CITY OF ALBUQUERQUE

June 24, 2024

**Re: Quik Trip Store # 7001
521 Unser Blvd. NW
Conceptual Traffic Circulation Layout for DFT Approval
Engineer's Stamp 05-31-24 (K10-D071)**

SHEET NUMBER:
C100
05 OF 25

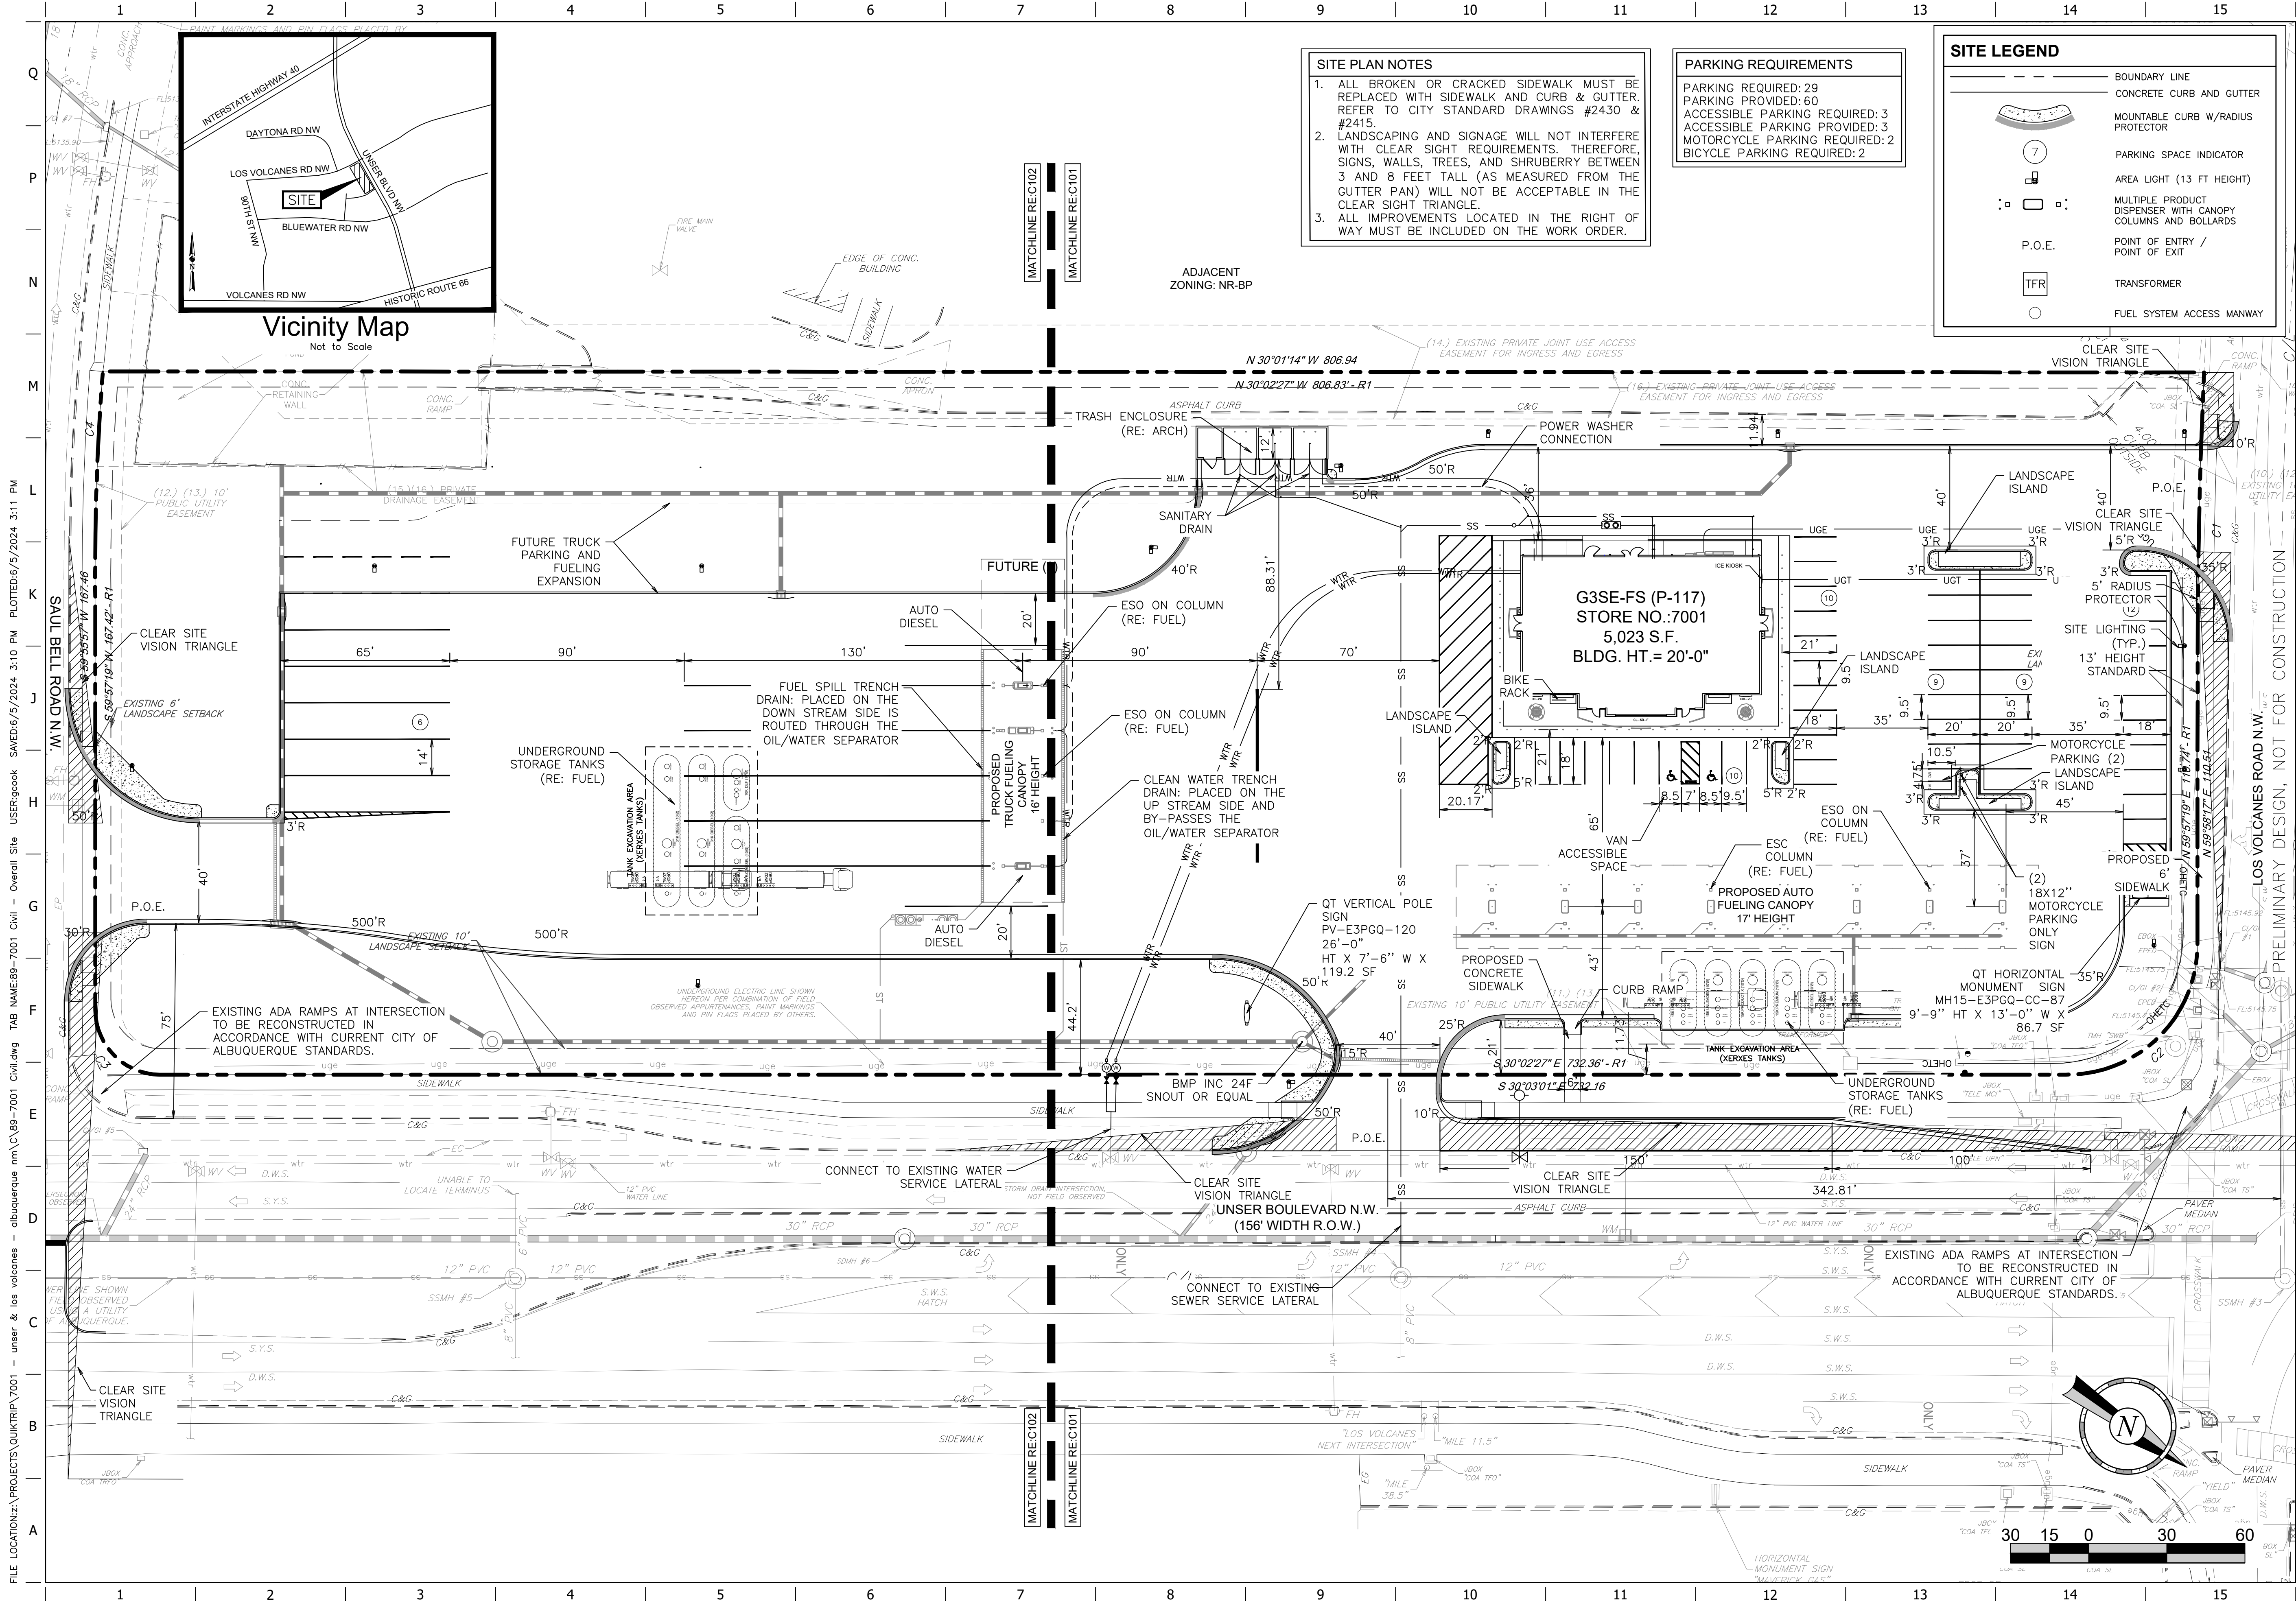
1. **An approved TIS must be provided.**
2. **Sheet C100: ADA parking aisle width should be minimum 8 ft.**
3. **Sheet details C510: ADA parking spaces width should be minimum 8.5 ft.**
4. **The minimum ADA pathway from the ADA parking aisle to the building entrance should be 6 ft. please show this dimension on the site plan.**
